**ADC Planning Consultation
Conservation/Design Officer Response**

Application Number	A/76/17/L
Address	Avenals Farm, Water Lane, Angmering
Description	Residential development within the curtilage of a listed building
Case Officer	David Easton
Date	18 May 2017

"STREET ELEVATION"
LONG NORTH ELEVATION
SCALE 1:200 AT A3

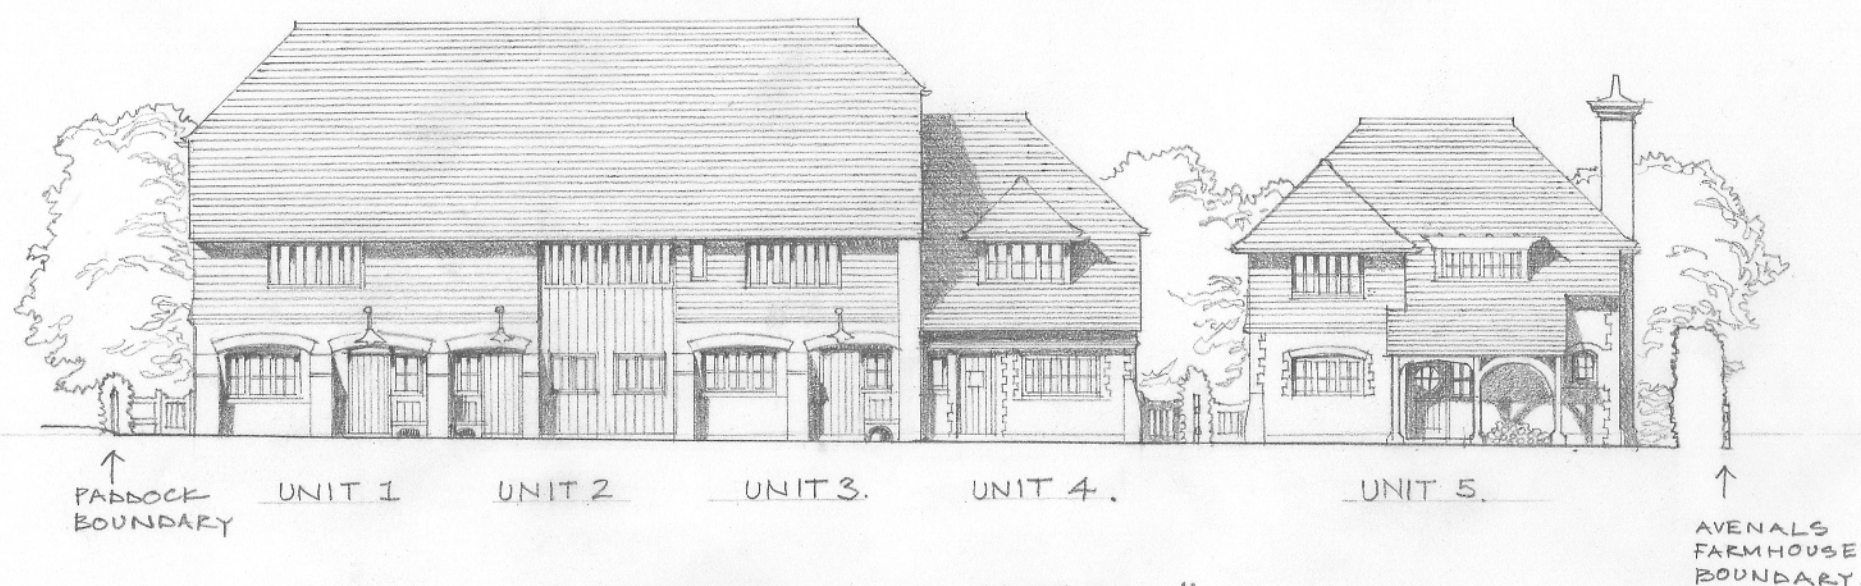
Historically Avenals Farmhouse would have been the only residential building within the farmstead, with other structures being in ancillary agricultural uses. The intention to construct five dwellings in close proximity to the listed farmhouse suburbanises its setting and diminishes the pre-eminence of the historic building, both within the farmstead and the wider landscape. The gradual erosion of the open farmland associated with the farmhouse blurs the distinction between what was historically an isolated group of agricultural buildings and the nearby settlement of Angmering, and thereby transforms the way in which the heritage asset is perceived.

Para 137 of the NPPF states that new development within the setting of a listed building should 'enhance or better reveal' the significance of the designated heritage asset. The present proposal does neither, as the intended residential development diminishes the significance of the listed building and clutters its setting.

The proposal is thus contrary to Para. 132 of the NPPF, which requires great weight to be given to the conservation of designated heritage assets and notes that significance can be harmed or lost through inappropriate development within their settings. Residential development of the site is fundamentally unacceptable in terms of HER DM1 and refusal is recommended.

The preceding objections notwithstanding, should the principle of development be found acceptable under other planning policies, the ensuing harm could be somewhat mitigated by a less intensive level of development of more simple form.

A modestly scaled pair of 1½ half storey ('Chalet style') dwellings - reminiscent of rural workers cottages - would have a less harmful presence on the site, as they would relate to the scale and form of other curtilage buildings and avoid overtly competing with, or greatly distracting attention from, the principle listed building. While this form of development would still result in some degree of harm, it would be far from the level which justifies refusal in terms of para. 133 of the NPPF.
